ENG-SP20003-R3-PrelimPlan-redlines.pdf Markup Summary

3
OF 17

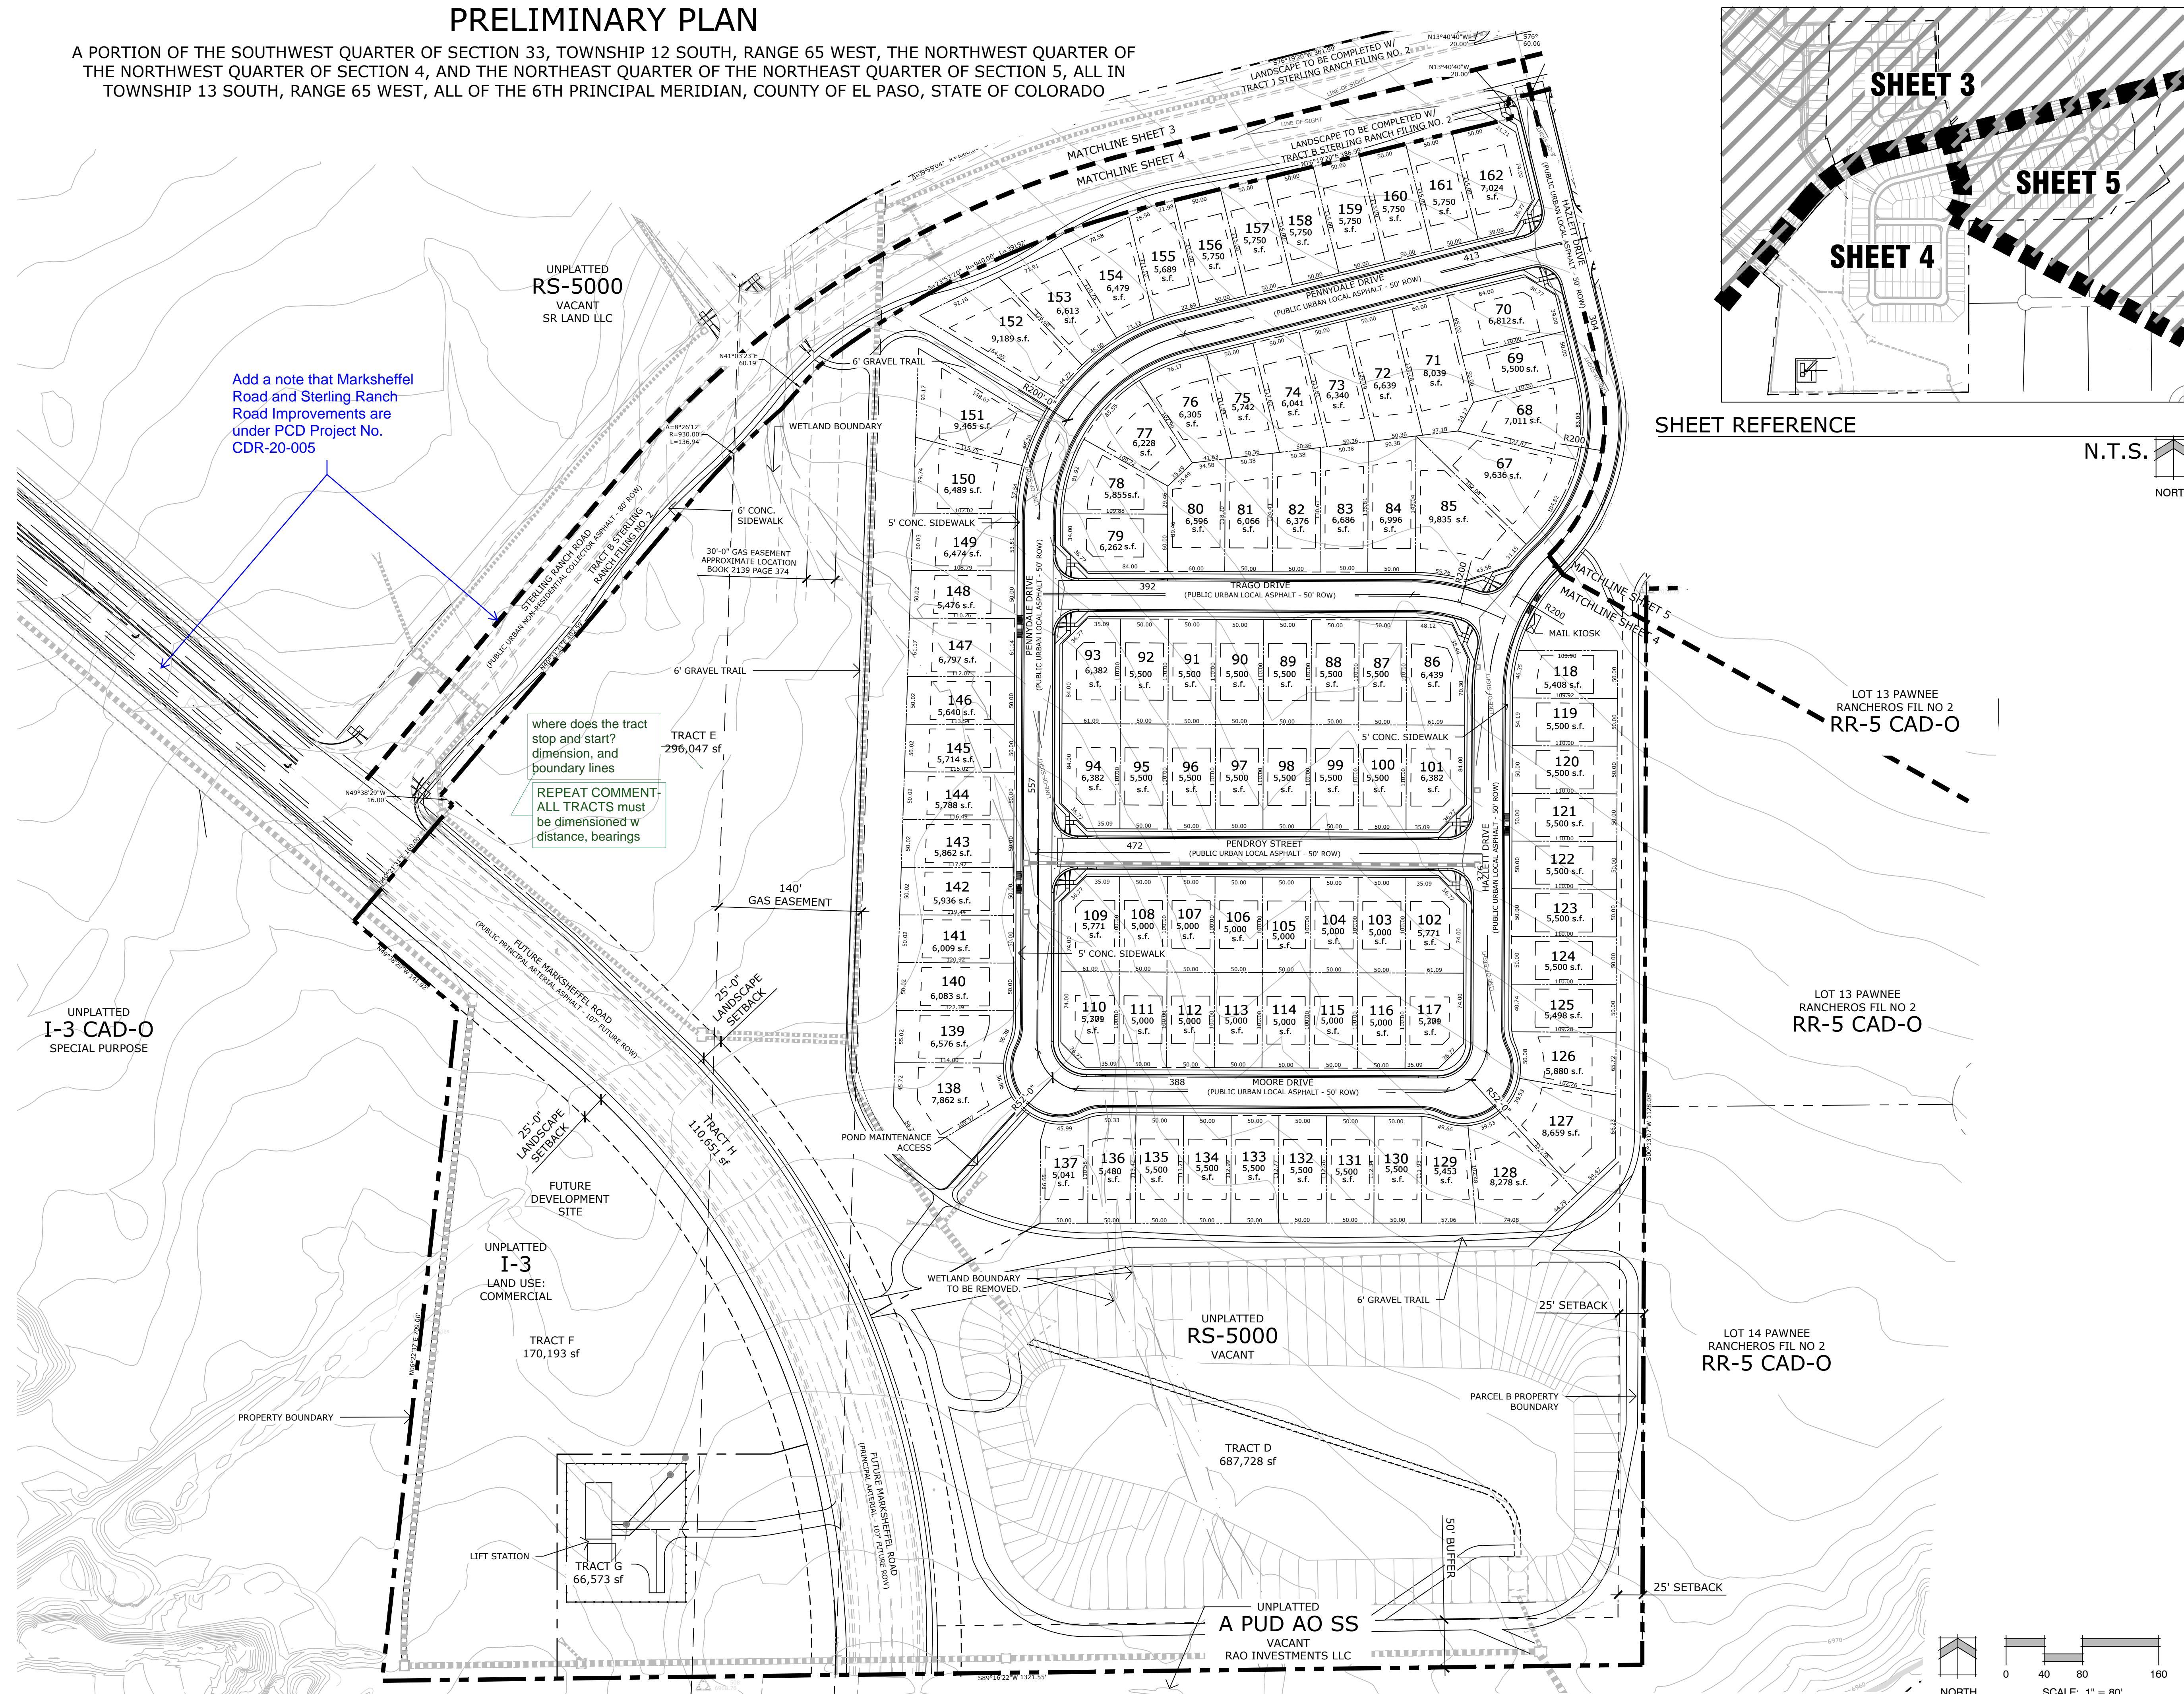
Subject: Callout
Page Index: 3
Date: 3/30/2021 11:48:42 AM
Author: dsdparsons
Color: ■
Layer:
Space:
Page Label: [1] Plan Sheet 3

tract distance bearings ; road CL data

Subject: Callout
Page Index: 3
Date: 3/30/2021 2:14:36 PM
Author: dsdparsons
Color: ■
Layer:
Space:
Page Label: [1] Plan Sheet 3

i cent tell where tract a, b, etc stop and starts;
please make sure each closes, and has
dimensions

Subject: Callout
Page Index: 3
Date: 3/30/2021 2:15:23 PM
Author: dsdparsons
Color: ■
Layer:
Space:
Page Label: [1] Plan Sheet 3

repeated comment not addressed ; all tracts must
have the closed boundary...

5
OF 17

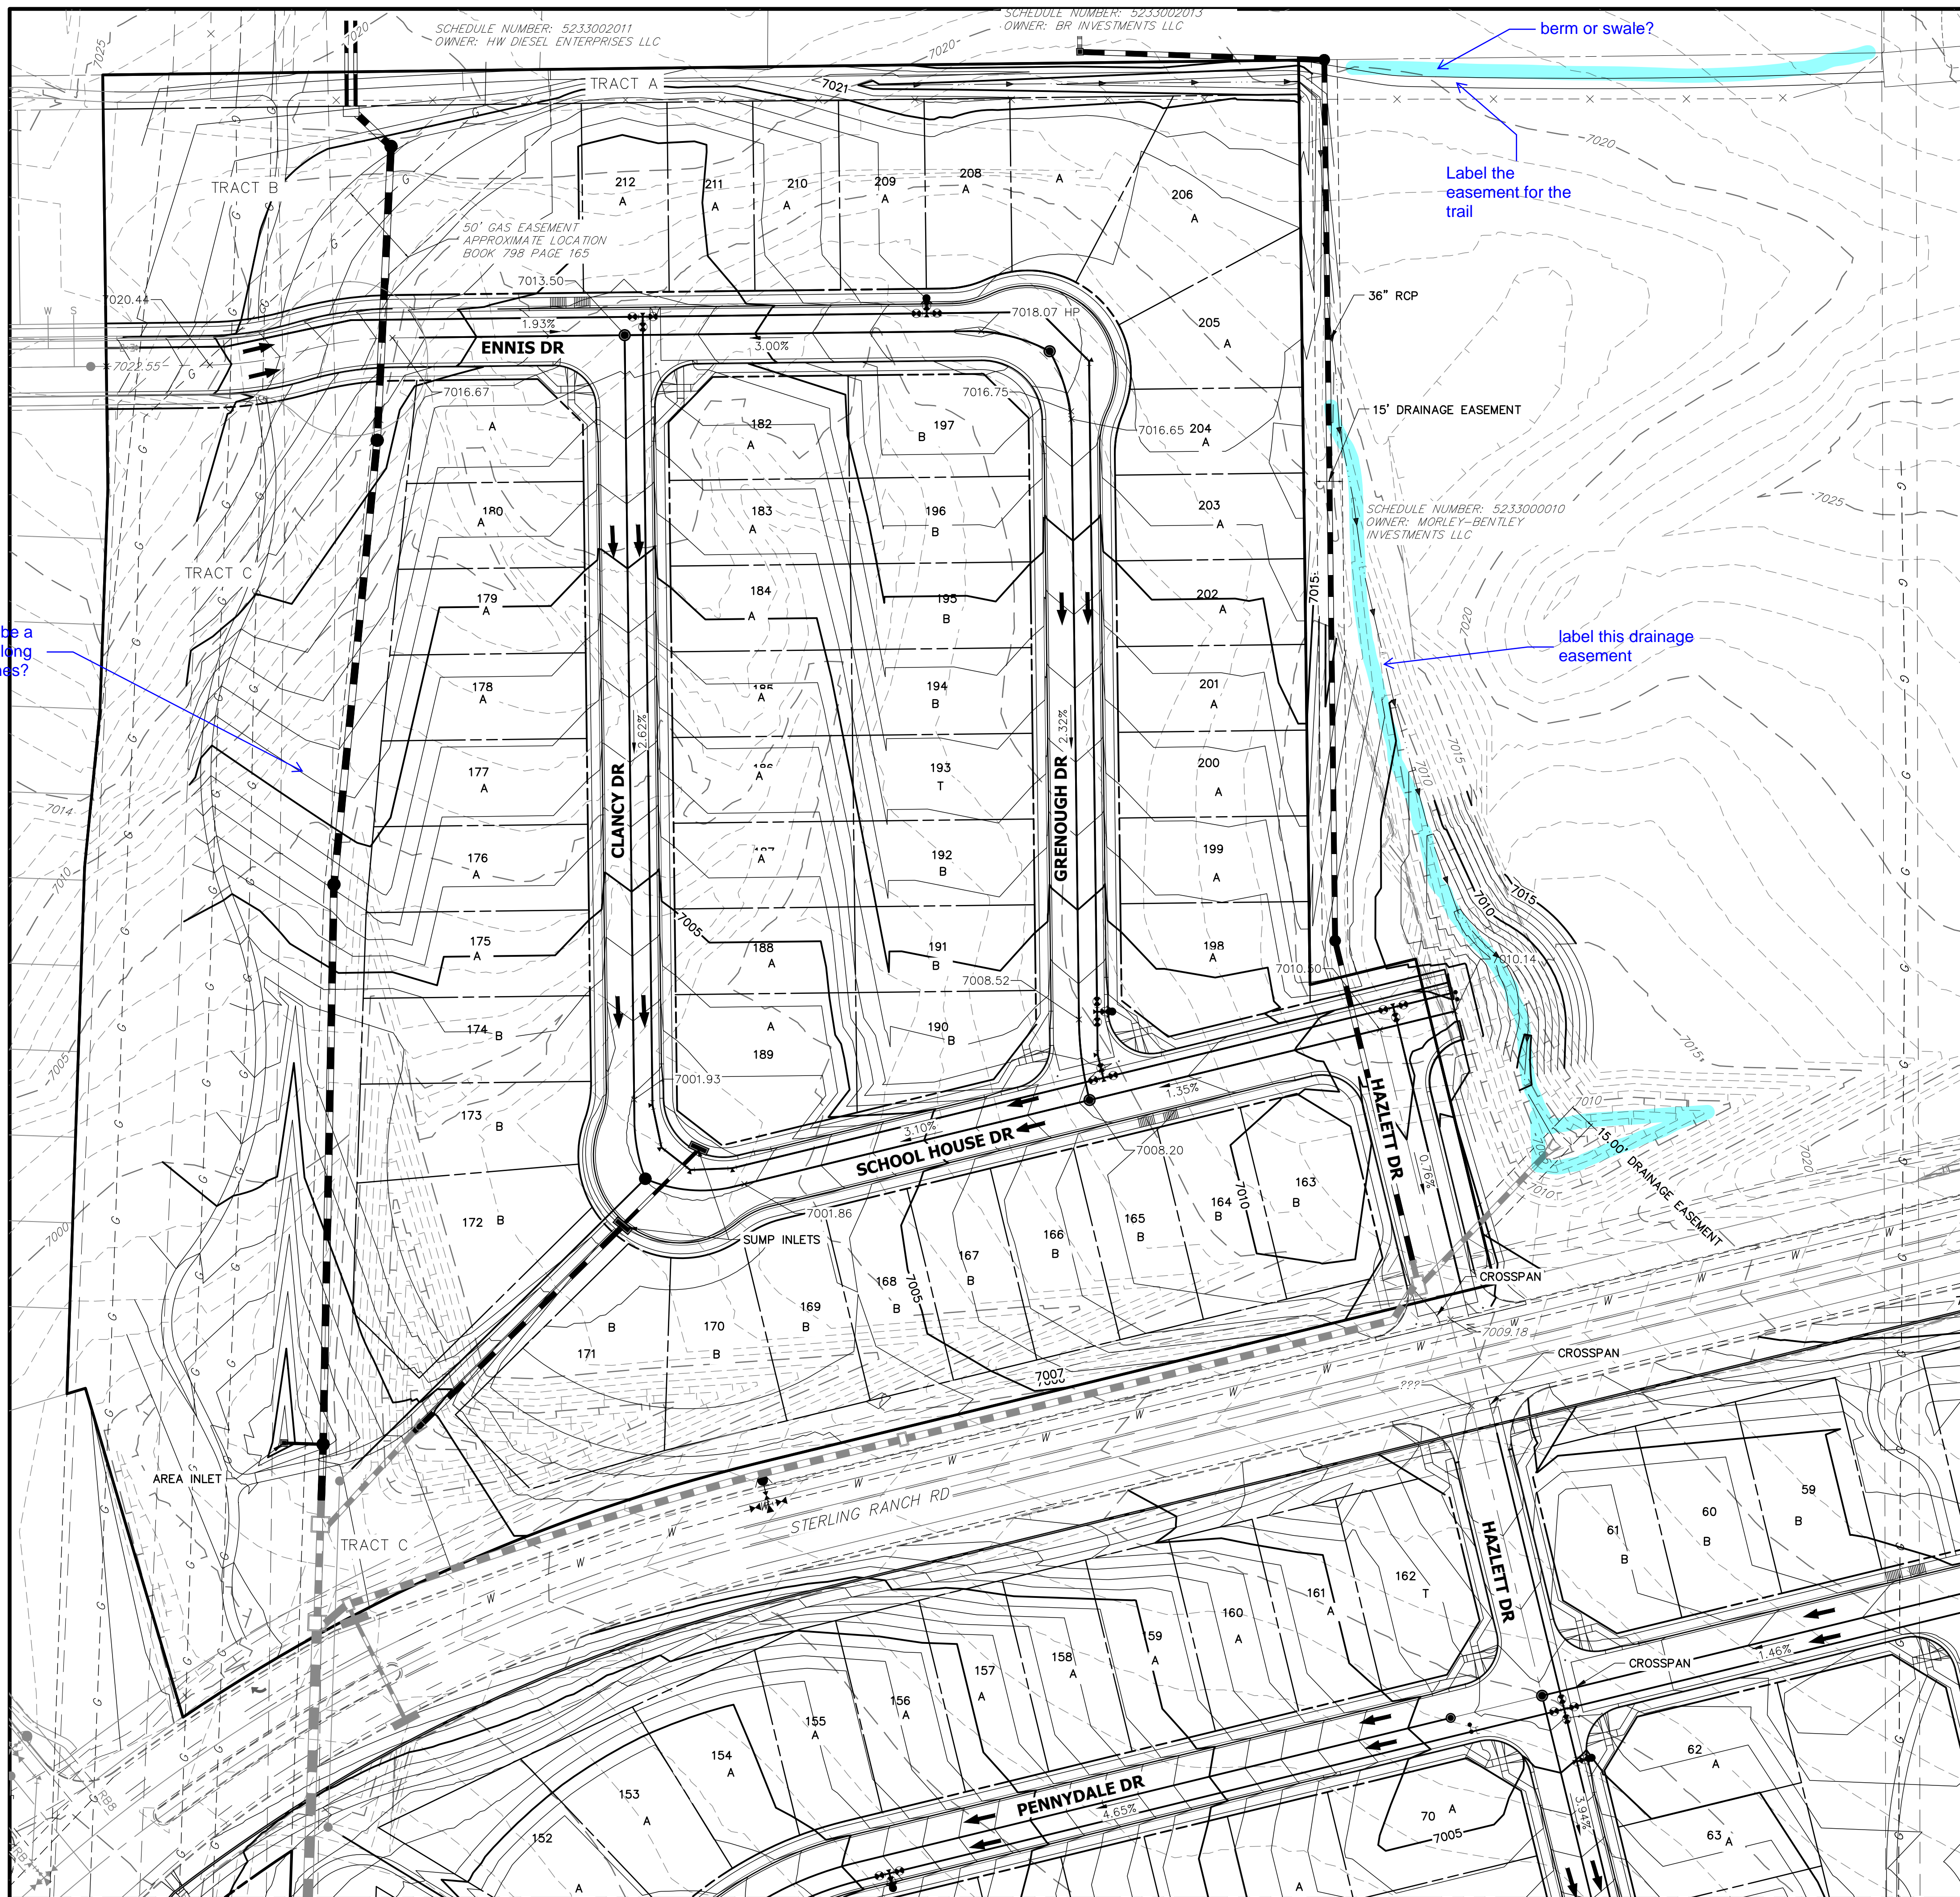
Subject: Callout
Page Index: 5
Date: 3/30/2021 2:22:40 PM
Author: dsdparsons
Color: ■
Layer:
Space:
Page Label: [1] Plan Sheet 5

what is the vertical line?

Subject: Callout
Page Index: 5
Date: 3/30/2021 2:24:12 PM
Author: dsdparsons
Color: ■
Layer:
Space:
Page Label: [1] Plan Sheet 5

tract - dimension, distance and bearings, on all tract's boundary lines (REPEAT COMMENT)

Subject: Callout
Page Index: 5
Date: 4/6/2021 1:16:50 PM
Author: dsdrice
Color: ■
Layer:
Space:
Page Label: [1] Plan Sheet 5

Add a note that Sand Creek Channel Improvements are under PCD Project No. CDR-20-004

SHEET 7 OF 17
JOB NO. 25188.02

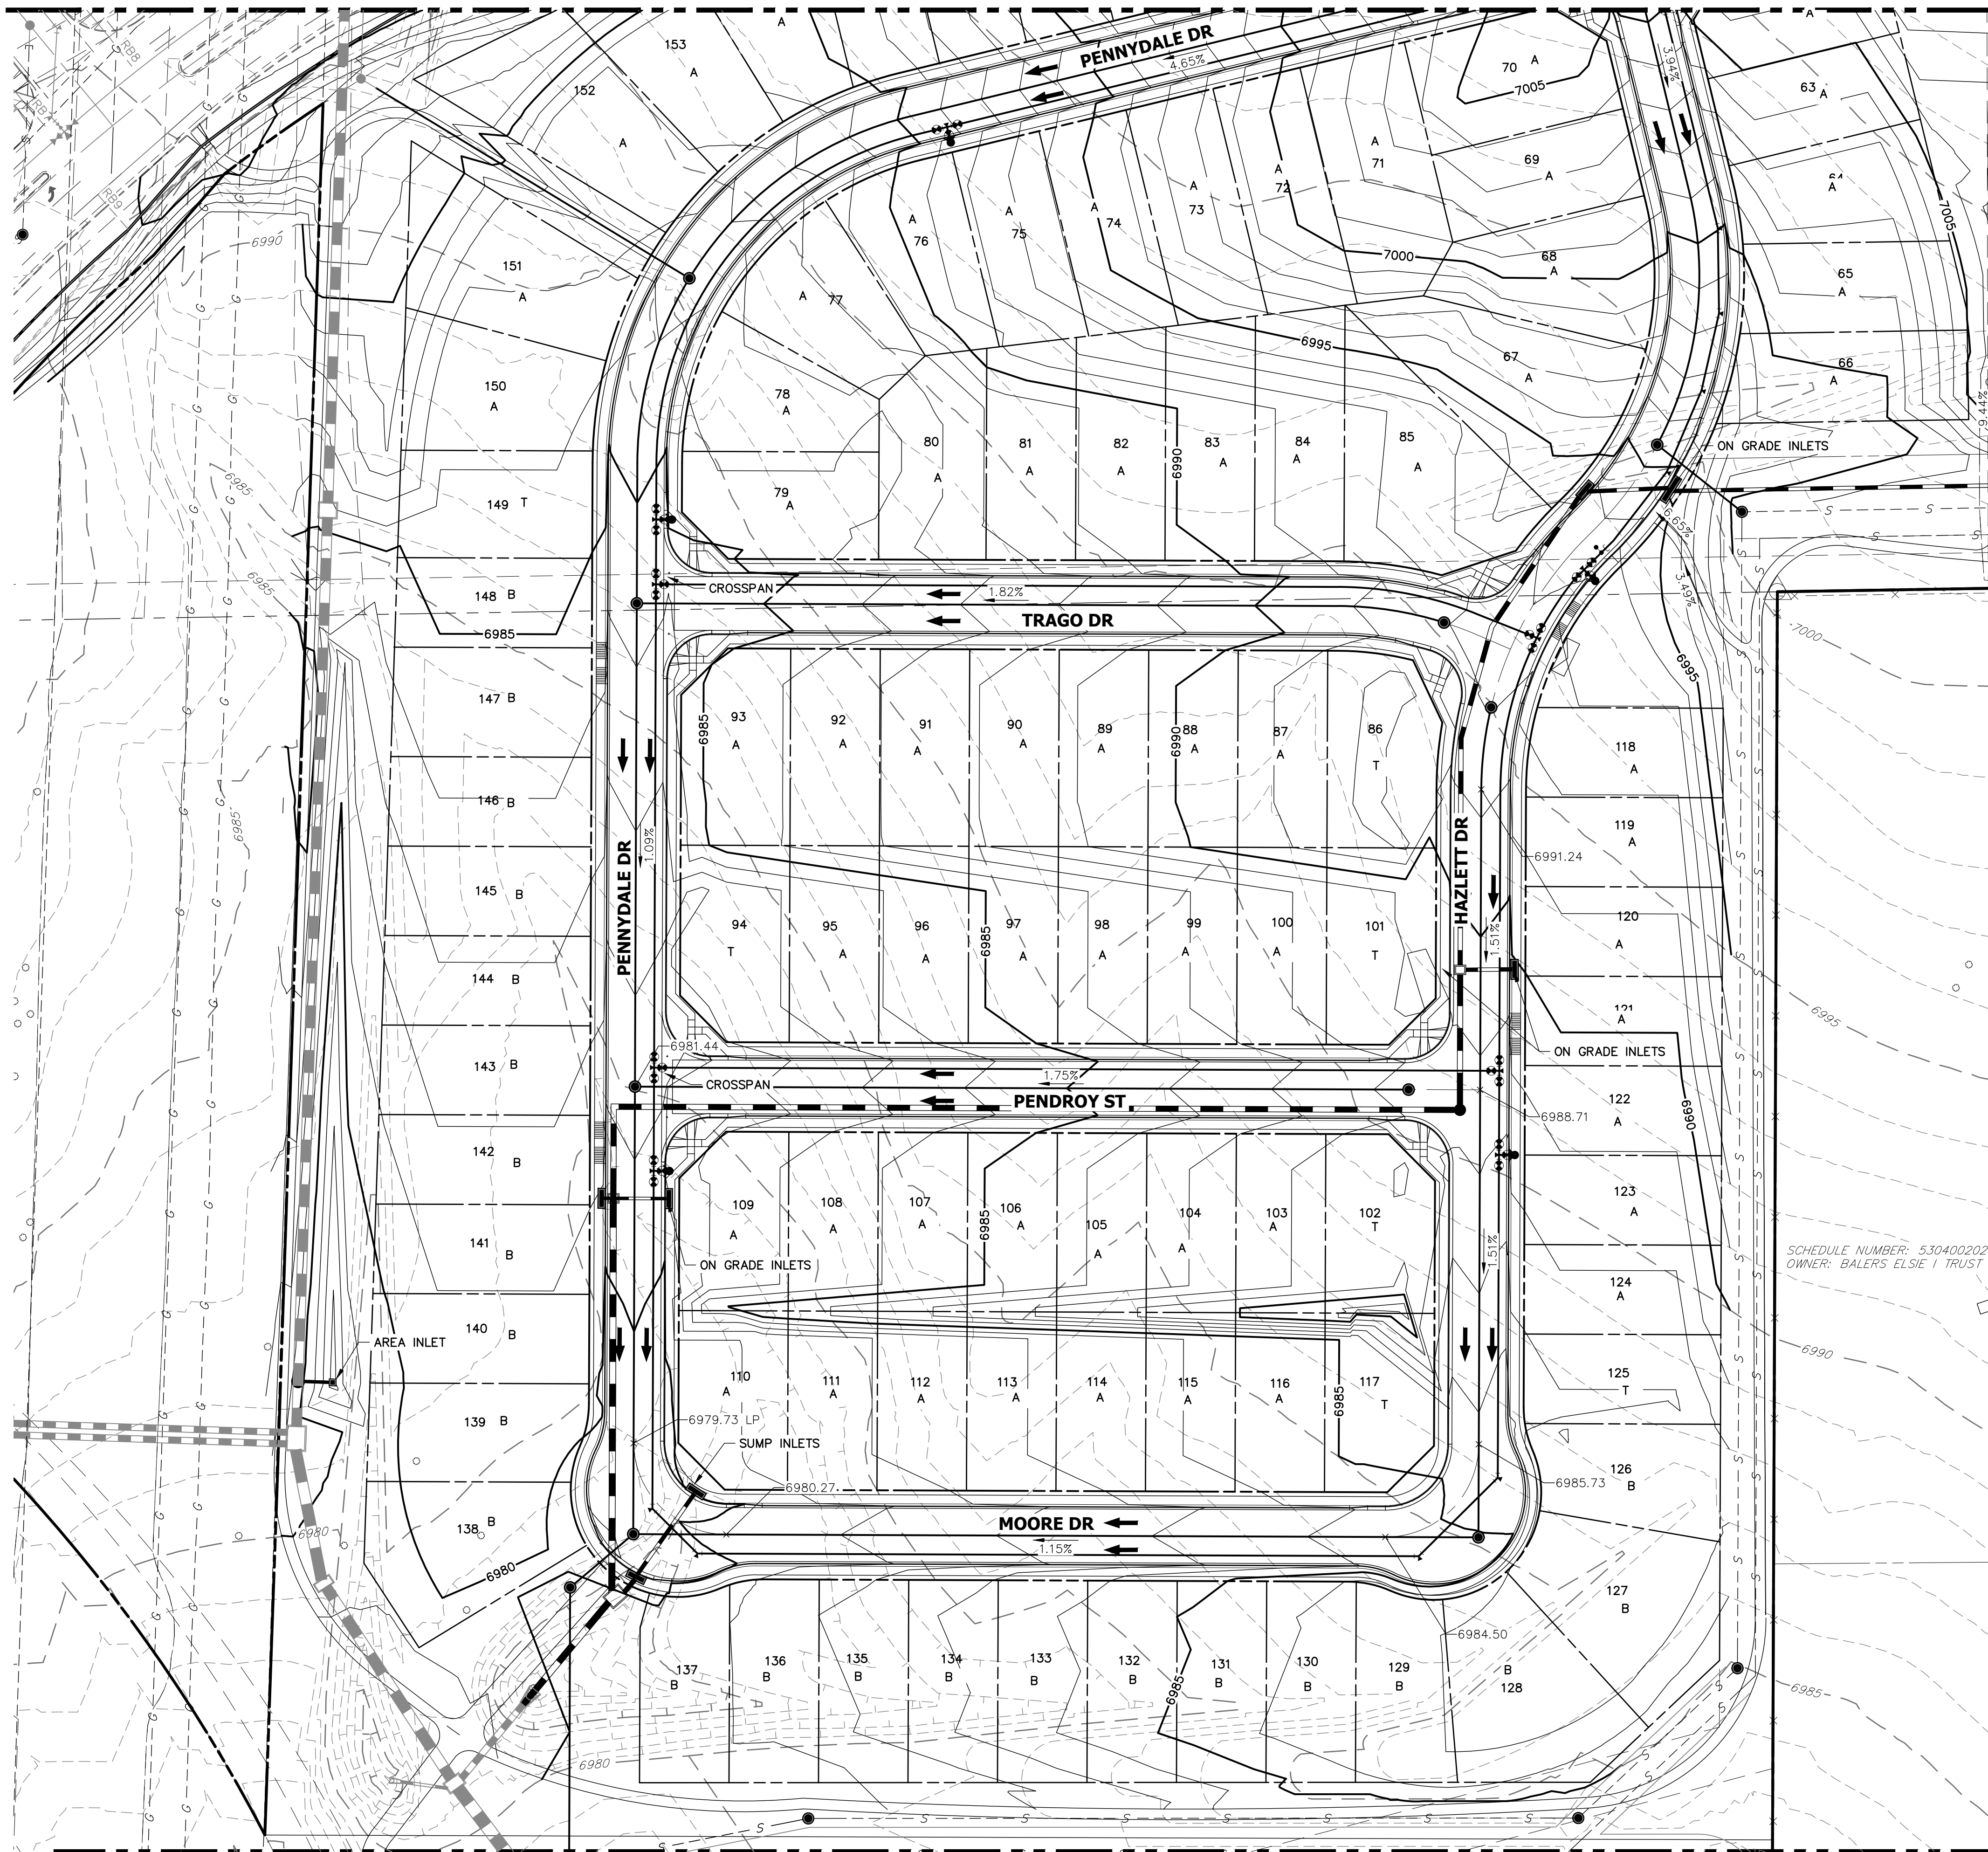
Subject: Callout
Page Index: 7
Date: 4/6/2021 1:53:48 PM
Author: dsdrice
Color: ■
Layer:
Space:
Page Label: [2] 7 Preliminary Grading Plan - preliminary grading plan (3)

adjust text/linetype
